re: **Grading and Site Servicing Plans Review**
Proposed Warehouse Building
6165 Thunder Road, Ottawa, Ontario

date: September 15, 2025

file: PG6430-MEMO.01

Scale:	1:400	Project Number:	CCO-23-1882
Drawn By:	FV		
Checked By:	RF	Drawing Number:	C101
Designed By:	FV

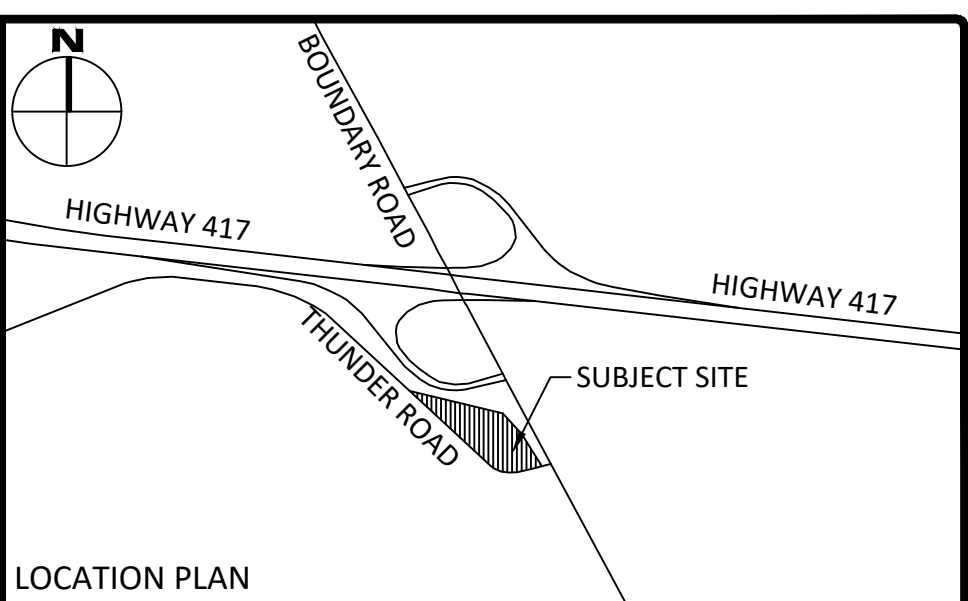
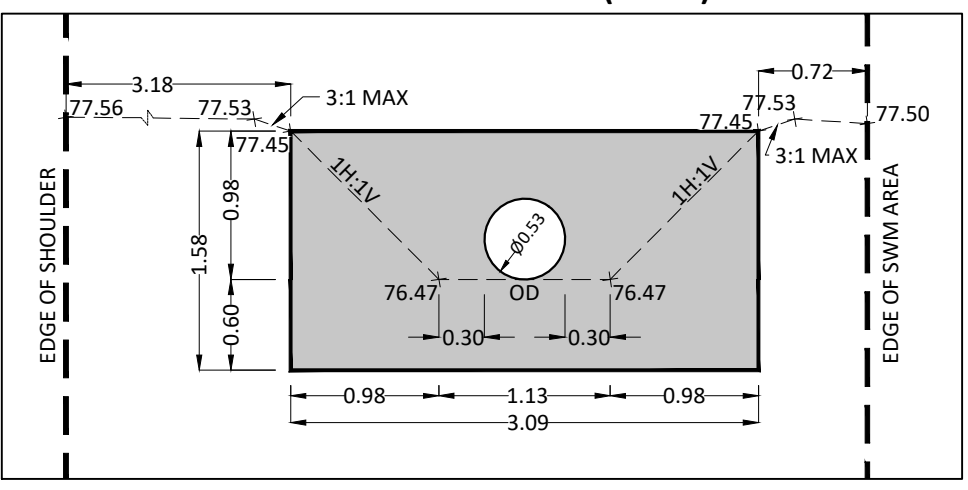
Based on our review of the above-noted drawing, the proposed building grading was found to be exceeding the permissible grade restriction assigned for the subject site within the footprint of the proposed building. The exceedances were found to range from 0.35 to 0.65 m above the permissible grade raise restriction. Therefore, LWF recommendations have been assigned to reduce the impacts of the load exerted from the additional soil needed to raise the grade to the proposed grades. It is important to note that the LWF will be recommended to be placed below the slab on grade as well as the perimeter of the proposed building extending horizontally a minimum 6 m beyond the foundation walls. Reference should be made to the attached Figure 1 – EPS Block Installation and Figure 2 - Lightweight fill Recommendations, attached to the end of this report.

Based on our review of the above noted grading plan, it is expected that the depressed ramp along the loading dock may have insufficient soil cover above the adjacent footings. The grading plan does not provide the underside of footing elevation of the footing directly adjacent to the depressed ramp. Therefore, one of the following options is recommended:

- ☐ Rigid insulation may be placed below the footings extending a minimum of 2.4 m horizontally beyond the footing face on the exterior side and 1.2 m horizontally on the interior side. The thickness and type of rigid insulation can be provided upon providing additional information regarding the soil cover and proposed underside of footing.
- ☐ Lowering the proposed footings to a minimum 1.5 m below the depressed slab to an elevation of 75.83 m to avoid the use of insulation below the proposed footing.
